**Consultation Response from KC,
Highways Development Management**

2023/93795 Land off, Wesley Avenue, Netherthong, Holmfirth, HD9 3UL

**Discharge condition 9 (construction management plan) on outline permission 2020/91146
(appeal decision APP/Z4718/W/21/3276678)
for erection of residential development**

Date Responded: 30/01/24

Designated Delivery Route A

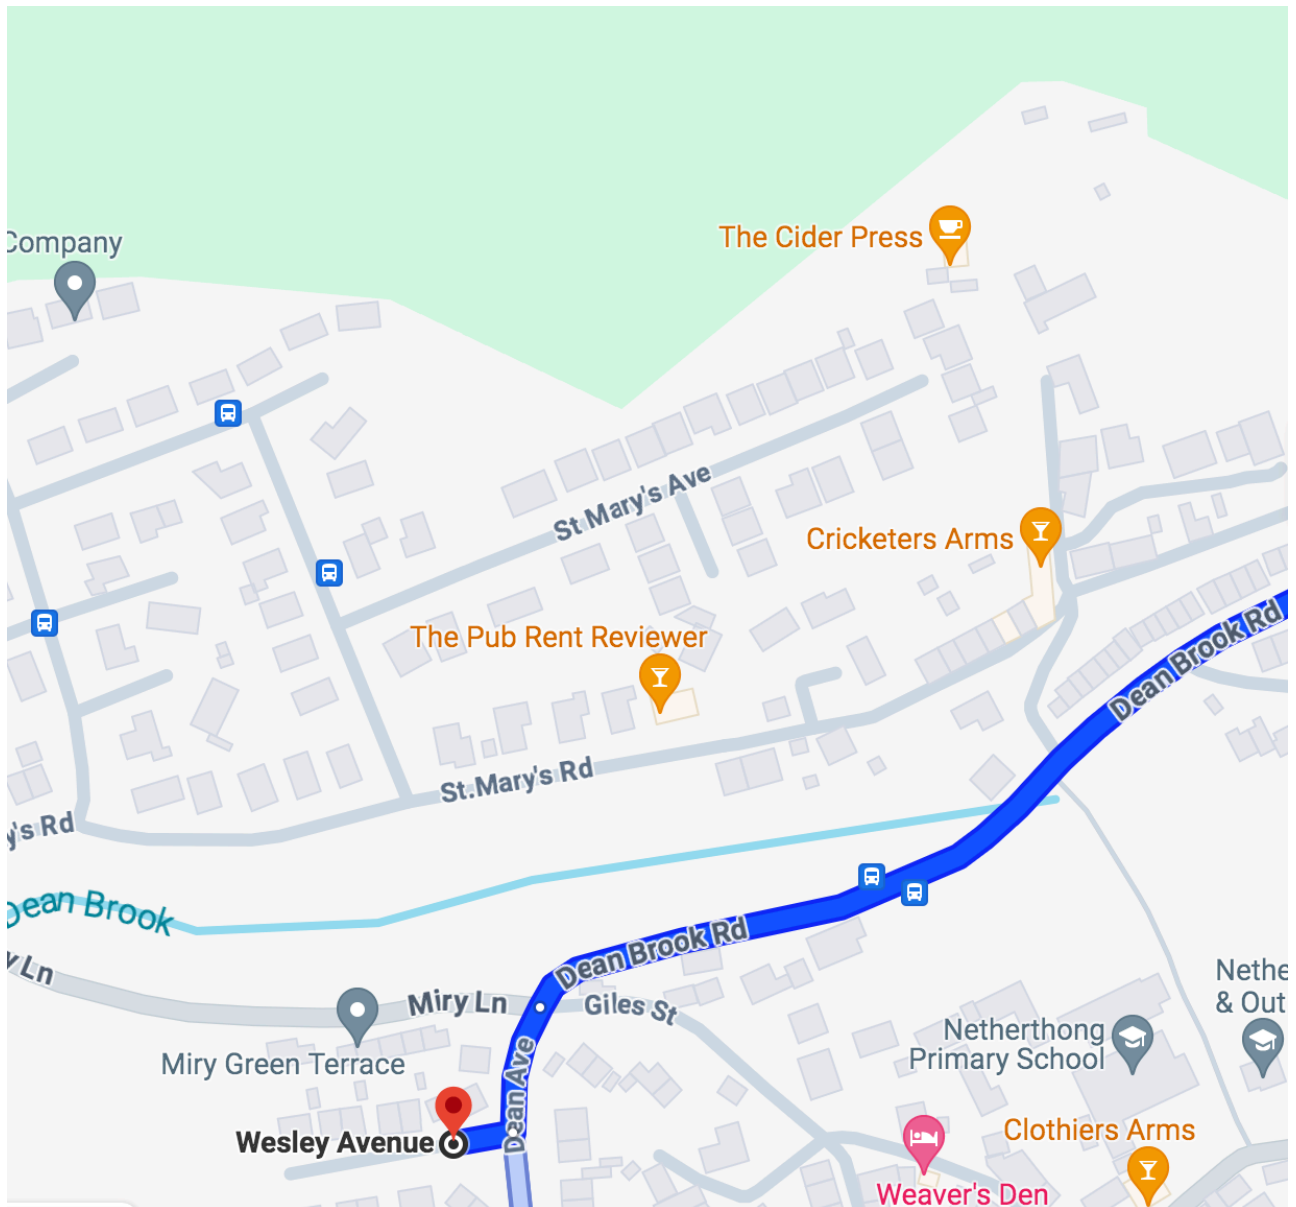
This section (and Appendix G) contains designated routes in to and from the site as access for construction traffic and deliveries. The plans were later revised in an email dated 15/01/24 which removed route B along Giles Street through the centre of Netherthong as the route was very narrow and unsuitable for delivery vehicles. The remaining route, Route A, was out to the east of the village via Dean Brook Road. The access plan only showed this route to the edge of the village and not beyond. Although this would be a better route than through Giles Street, beyond the edge of the village the route is narrower and there are no pedestrian facilities and beyond the area there are no suitable links on to the principal highway network as most of the routes to the A6024 are marked as not being suitable for HGVs or goods vehicles, including the link to the village along the B6107 and so this route would only be suitable for vehicles up to a transit van size and no larger. For this reason, we cannot accept the routings for HGVs as provided within the CMP.

This contains the Construction Traffic Routes. It is noted that Route B has been removed from the application. We would like to see the proposed route to Meltham via B6107 Moor Road added as the only suitable heavy vehicle route.

Designated Delivery Route B

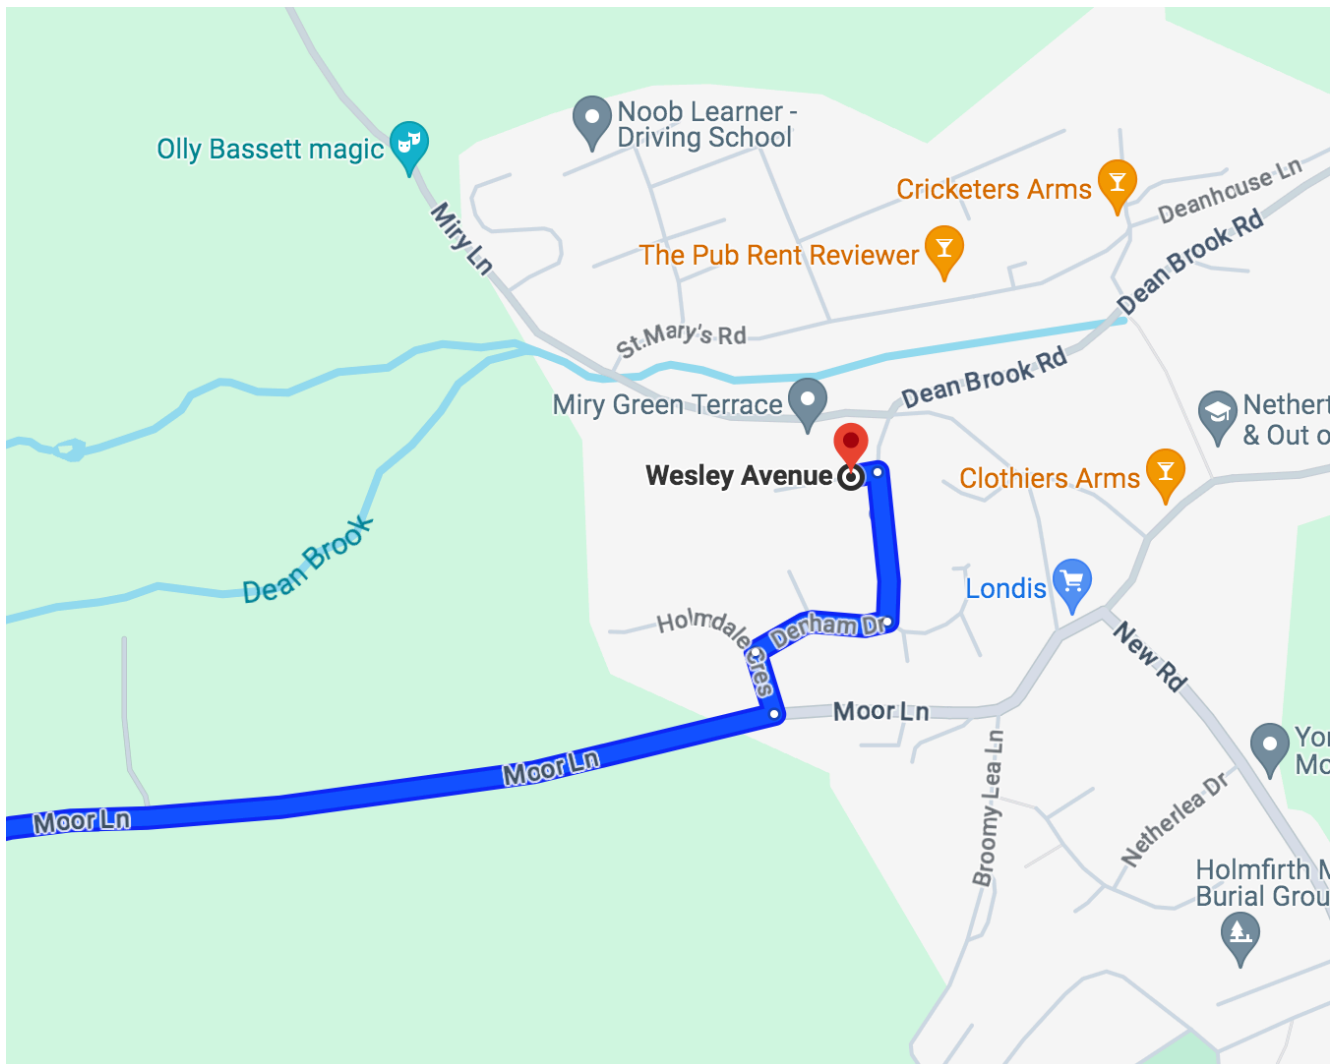
The only route from the site to the principal highway network that is suitable for HGV traffic would be to head south along Dean Avenue, then on to Denham Drive and Holmdale Crescent and then turn right on to B6107 Moor Lane towards Meltham. It is unfortunate that the first section of this route is through a residential estate, but the roads are more modern than the historical layout of the rest of the village and are built to better standards and have pedestrian footways which would be safer. They are also wide enough to allow a HGV and a car to pass safely.

### CONSTRUCTION PHASE PLAN AND SITE PLAN FOR BLUEBELL MEADOWS, NETHERTHONG PHASE 1-3A

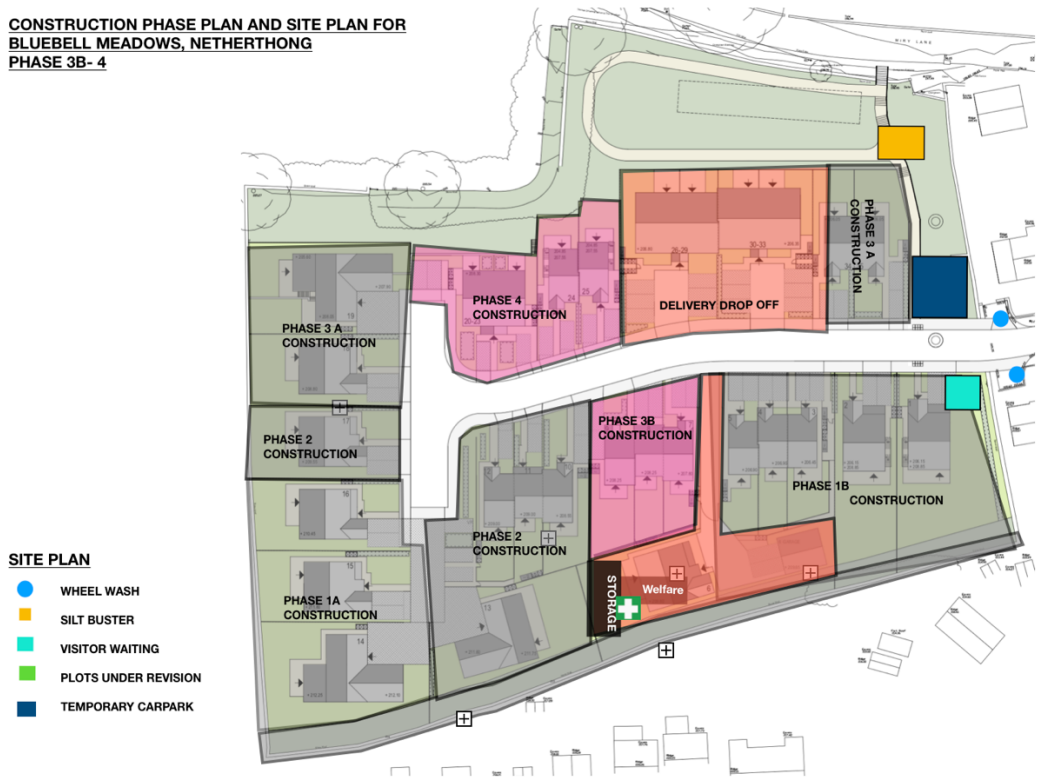
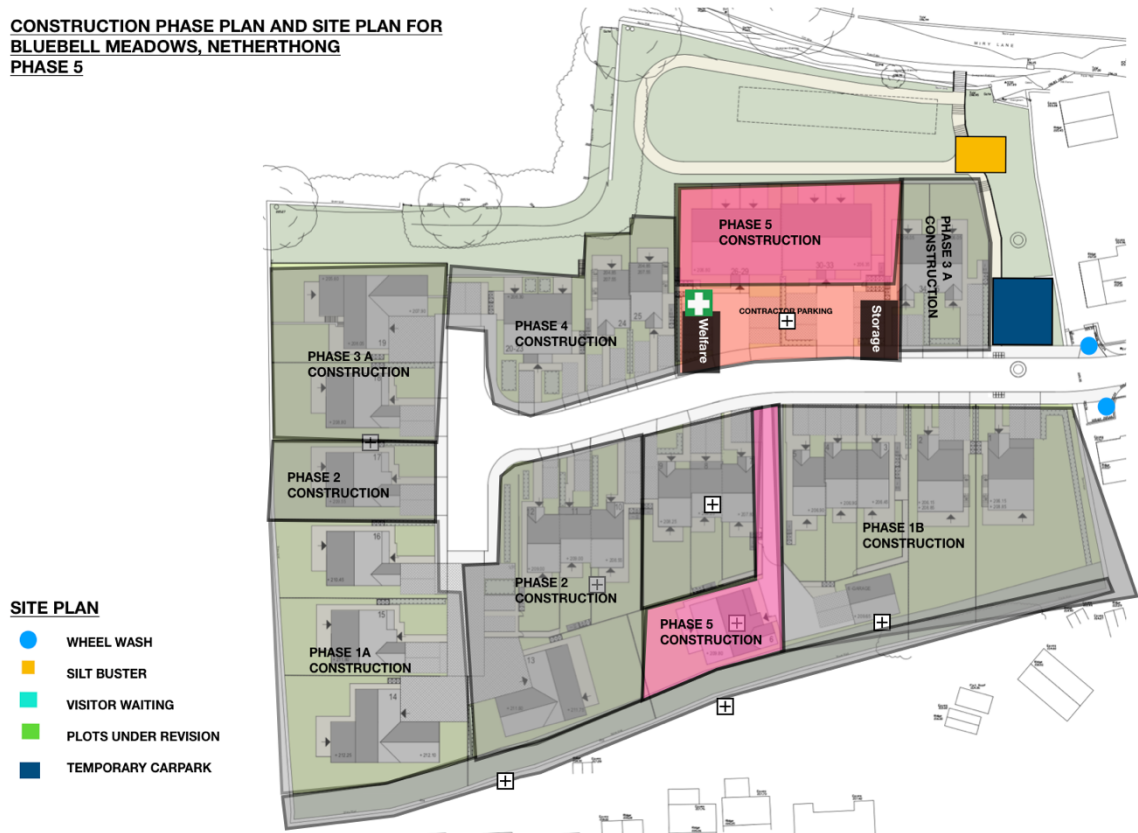
Construction Phase drawing

This may need revising to cover each of the 6 specific stages of the development process, starting with groundworks and then covering each construction phase as the areas indicated for parking and storage will eventually be built on and will no longer be available for parking, materials storage and welfare facilities.
